Our ref: TR010066

18 December 2024

**A46 COVENTRY JUNCTIONS (WALSGRAVE) – TR010066
RESPONSE TO ADVICE RECEIVED FROM THE PLANNING INSPECTORATE UNDER
SECTION 51 OF THE PLANNING ACT 2008**

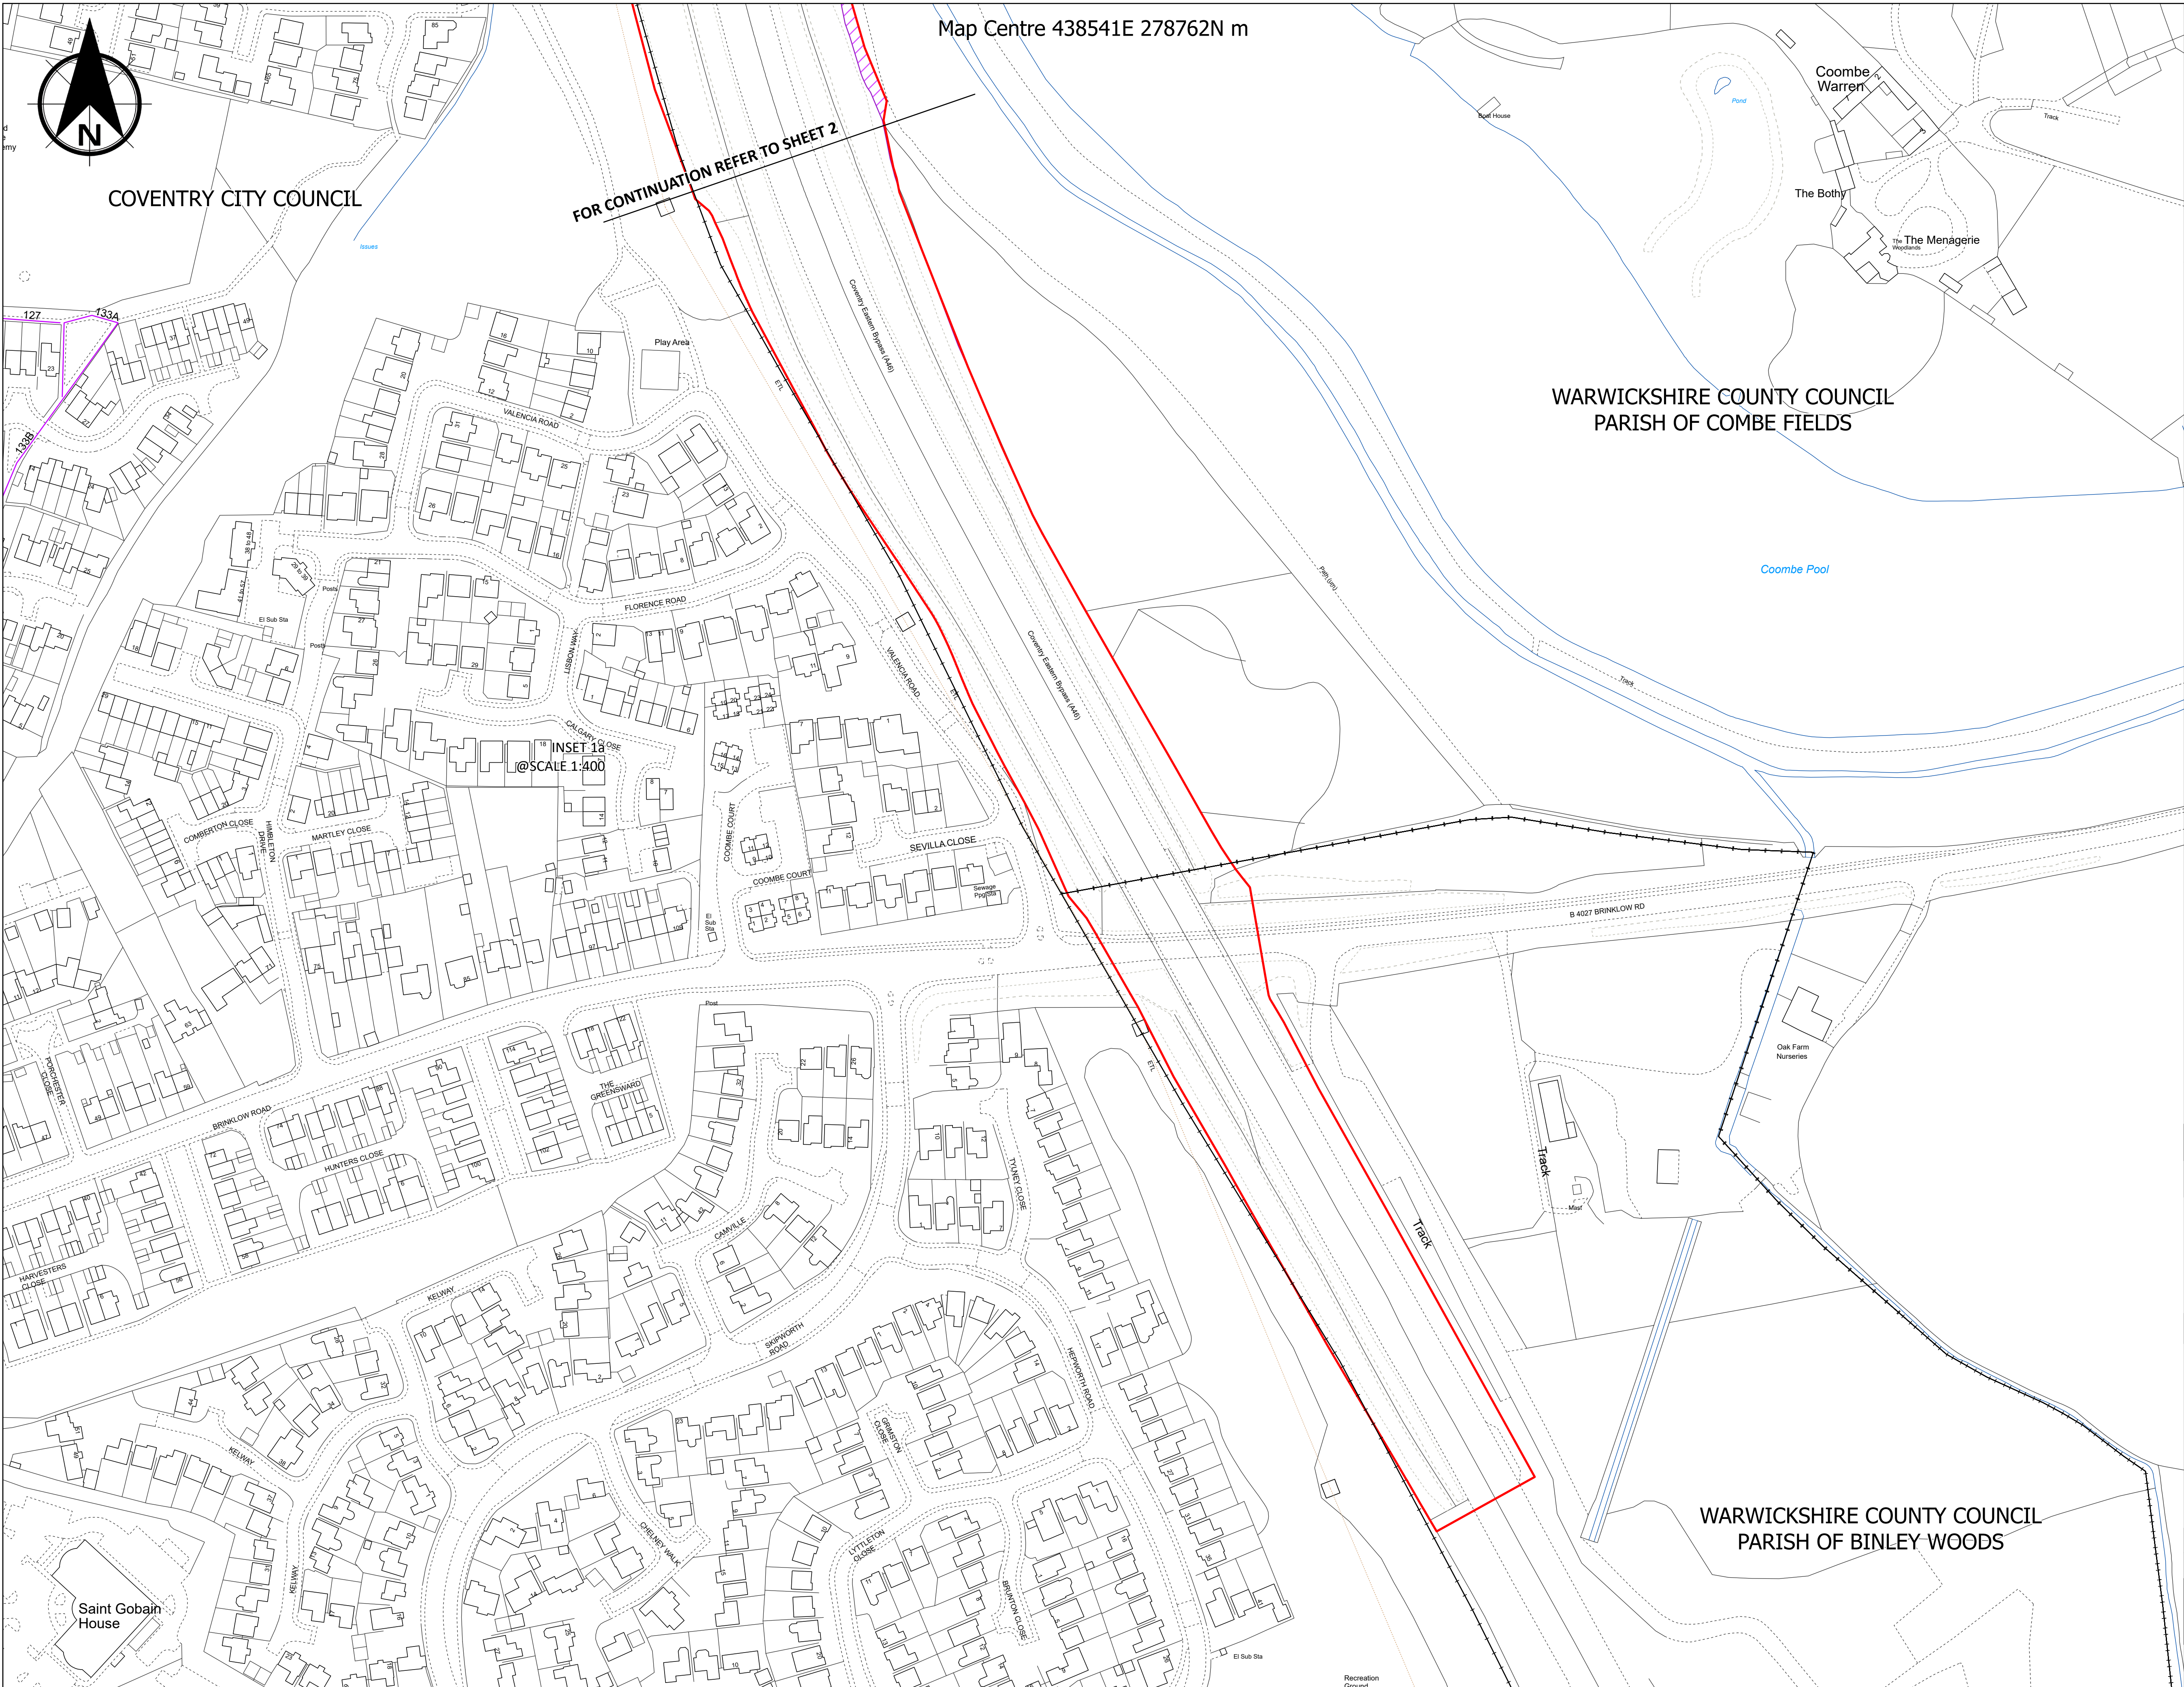
4c	Statement of Reasons (Doc 4.1) Plots 2/2 and 2/1e should appear in the last line of the table as open space land only to be compulsorily acquired for a temporary purpose	The two plots of open space land are not being compulsorily acquired for a temporary purpose, they are only subject to temporary possession. The Applicant has therefore not added them to that entry in Table 7-1 of the Statement of Reasons (TR01006/APP/4.1).
4d	Environmental Statement - Appendix 7.1 – ZTV and Verified Photomontage Methodology (Doc 6.3) The cover page for the Environmental Statement Appendix 7.1 ZTV and Verified Photomontage Methodology has been incorrectly labelled as 6.1 instead of 6.3.	The front cover of Environmental Statement Appendix 7.1 ZTV and Verified Photomontage Methodology (TR01006/APP/6.3) has been amended to show document reference 6.3 instead of 6.1.
4e	Environmental Statement – Appendix 13.1 – Flood Risk Assessment (Doc 6.3) Whilst it is noted that the exception test appears to consider the requirements of Flood Zone 3b, the FRA does not provide specific information to differentiate between land within Flood Zones 3a and 3b (See accompanying s51 advice).	See Ref 3 above.

Document Title	Document Number	Planning Inspectorate Document Reference	Revision	Reason for Update
General Arrangement	TR010066/APP/2.6	APP-017	Rev 1	To respond to the section 51 advice. See Table 1, Ref 4b.
Special Category Land Plans	TR010066/APP/2.8	APP-019	Rev 1	To respond to the section 51 advice. See Table 1, Ref 4a.
Funding Statement	TR010066/APP/4.2	APP-009	Rev 1	To respond to the section 51 advice. See Table 1, Ref 3.
Environmental Statement Appendices Appendix 7.1 ZTV and Verified Photomontage Methodology	TR010066/APP/6.3	APP-070	Rev 1	To respond to the section 51 advice. See Table 1, Ref 4d.
Environmental Statement Appendices - Appendix 8.11 Wintering Bird Report	TR010066/APP/6.3	APP-086	Rev 1	To make a minor amendment, independently identified by the Applicant: During consultation with Natural England, it was brought to our attention that Cirl Bunting, a rare species for the locality, had been shown on Figure 2. The inclusion of this was an error. This species was not present on site and not recorded during surveys. This has been removed from

Drawing Title: SPECIAL CATEGORY LAND PLANS REGULATION 5(2)(I) SHEET 2 OF 5

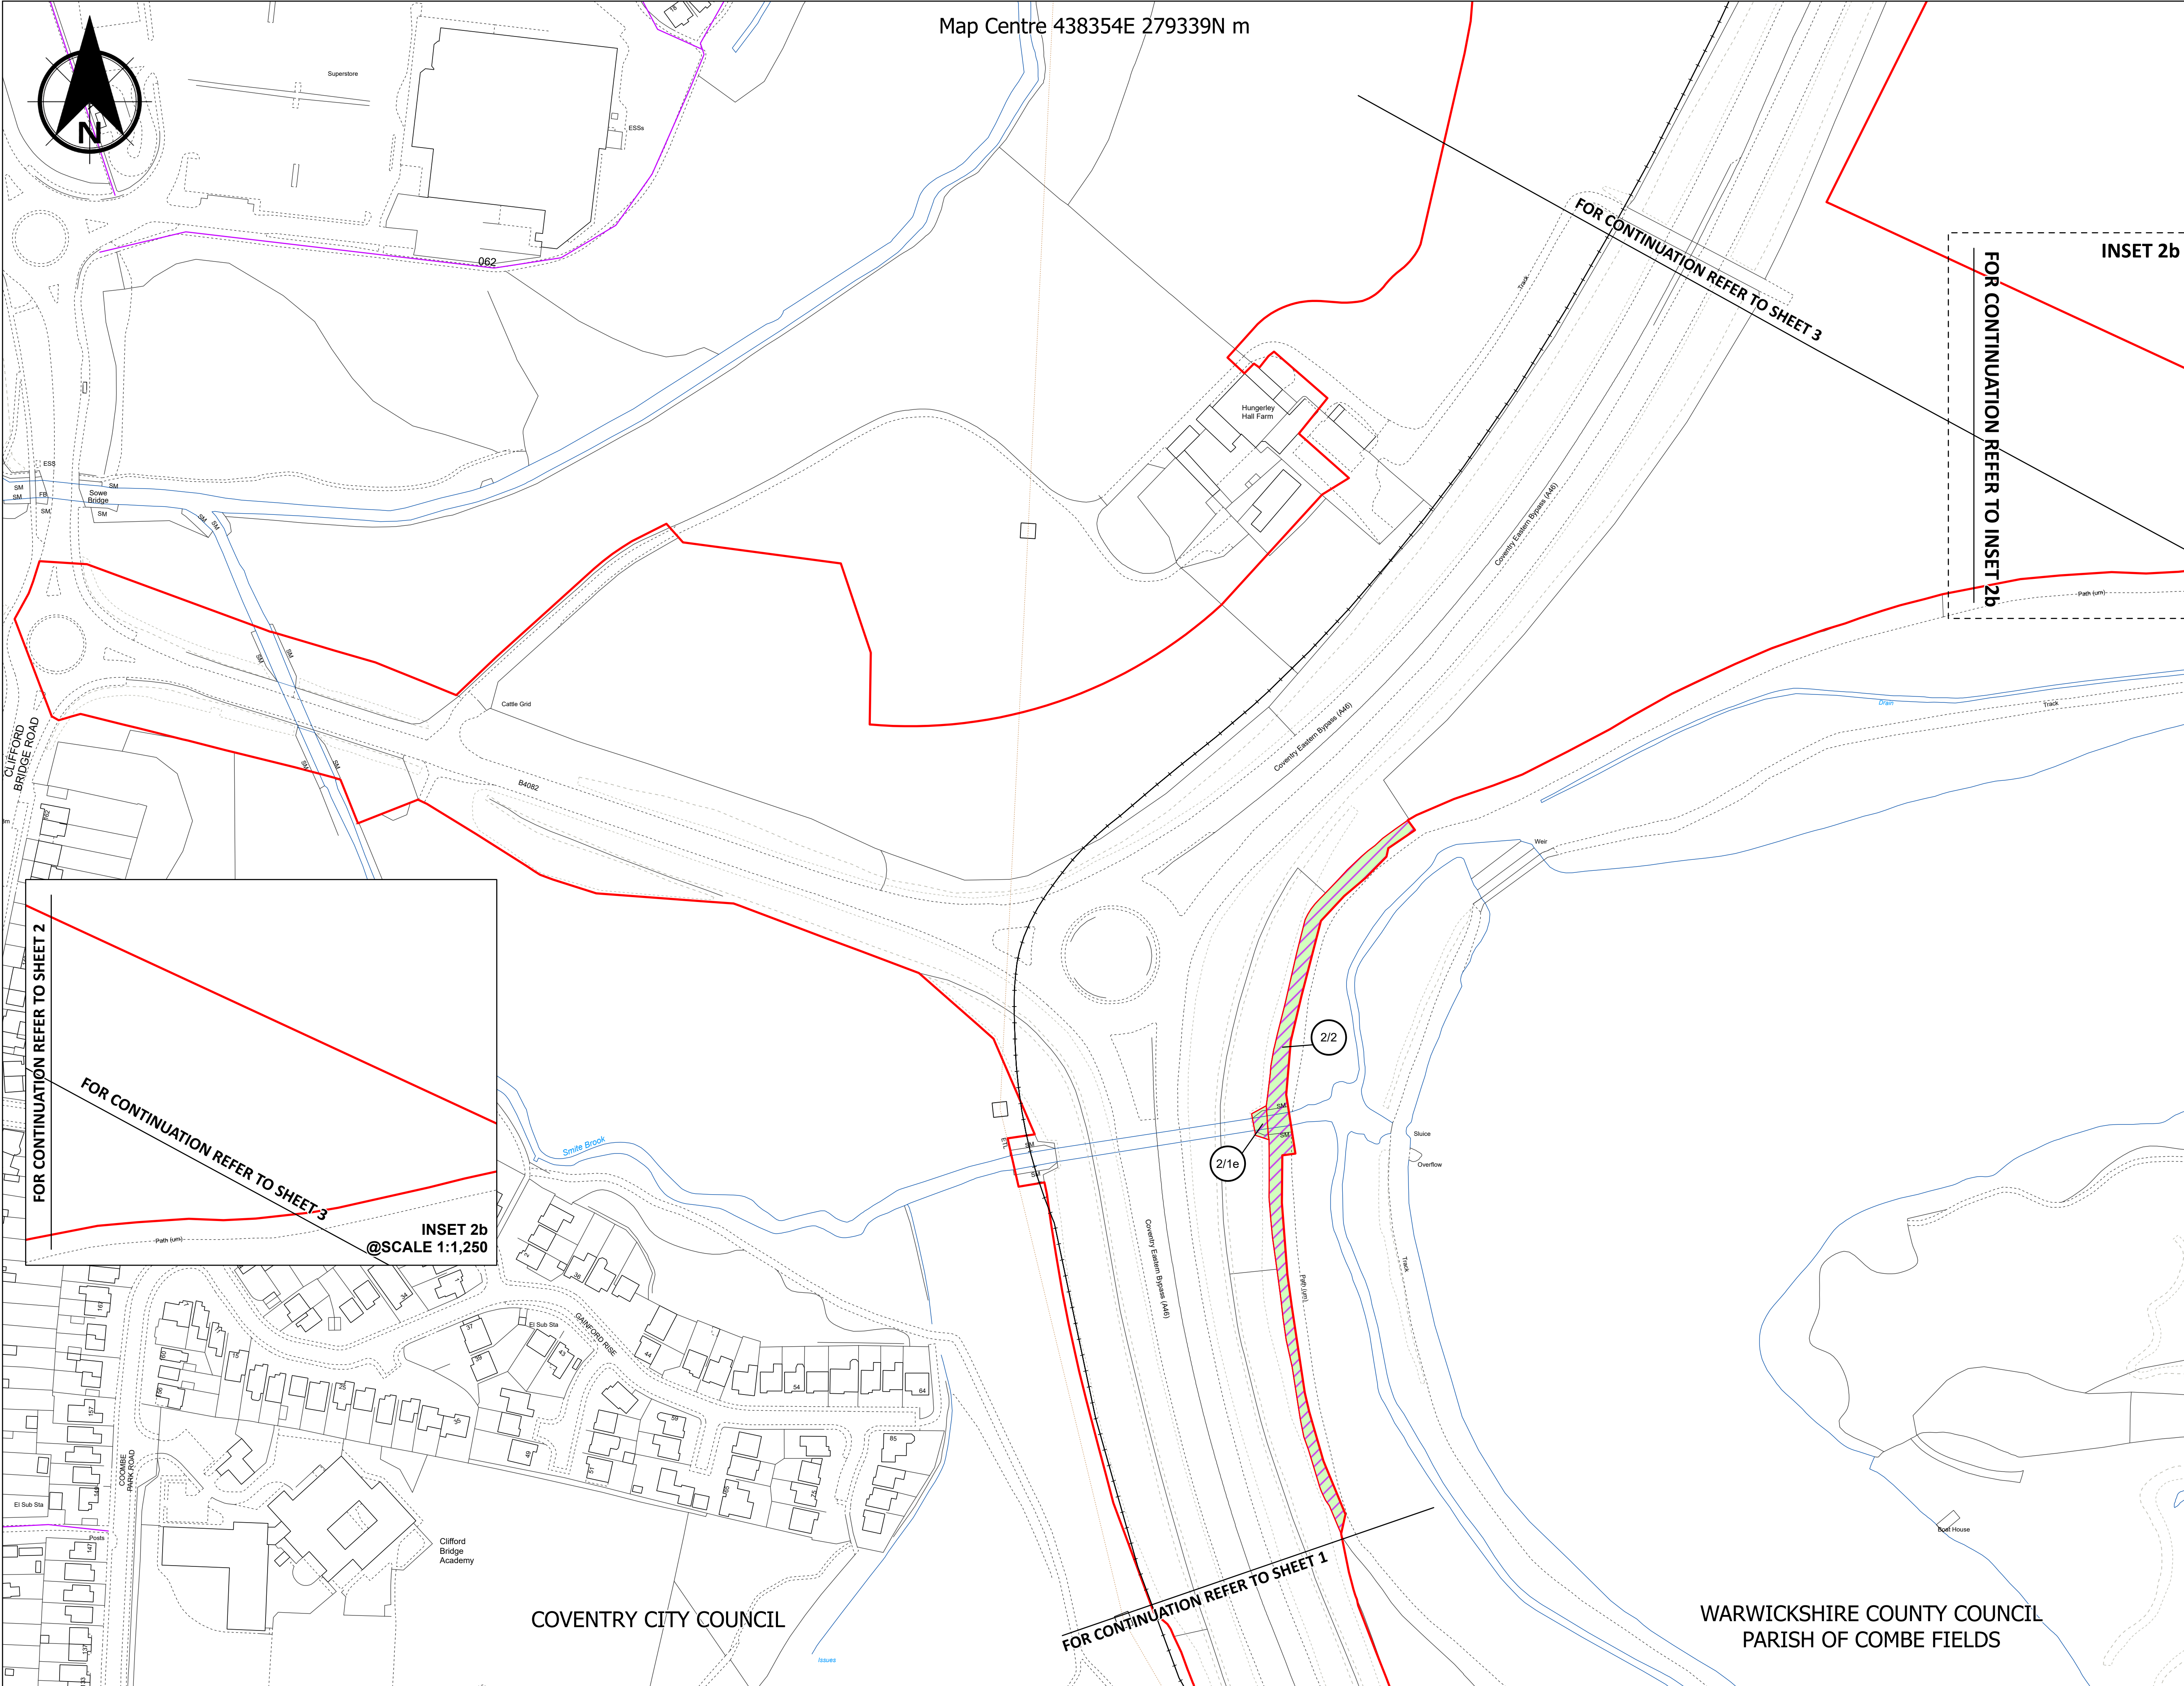
Ref.	Section 51 advice received from the Inspectorate	The Applicant's response to the section 51 advice
	Please note this list is not exhaustive and other errors and omissions may be identified during pre-examination and examination. Response	
4a	Plans The Applicant should ensure that all key features are clearly identified on plans. For example, on the Special Category Land Plans (Doc 2.8), plots 2/2 and 2/1e not clearly identified as open space land.	The Special Category Land Plans (TR01006/APP/2.8) have been reviewed and amended in accordance with the section 51 advice, hatching has been added to clearly identify the open space land (plots 2/2 and 2/1e) within the Order Limits and this has been added to the Legend. This is only applicable to Sheets 1 and 2 of the Plans.
4b	Also, in General Arrangement (Doc 2.6), the proposed maintenance layby and Hungerley Farm Overbridge are not clearly identified.	The General Arrangement (TR01006/APP/2.6) has been reviewed and amended in accordance with the section 51 advice, with labels added to clearly identify the proposed maintenance layby and the existing Hungerley Hall Farm Accommodation Overbridge. This is only applicable to Sheets 2 and 4 of the Plans.
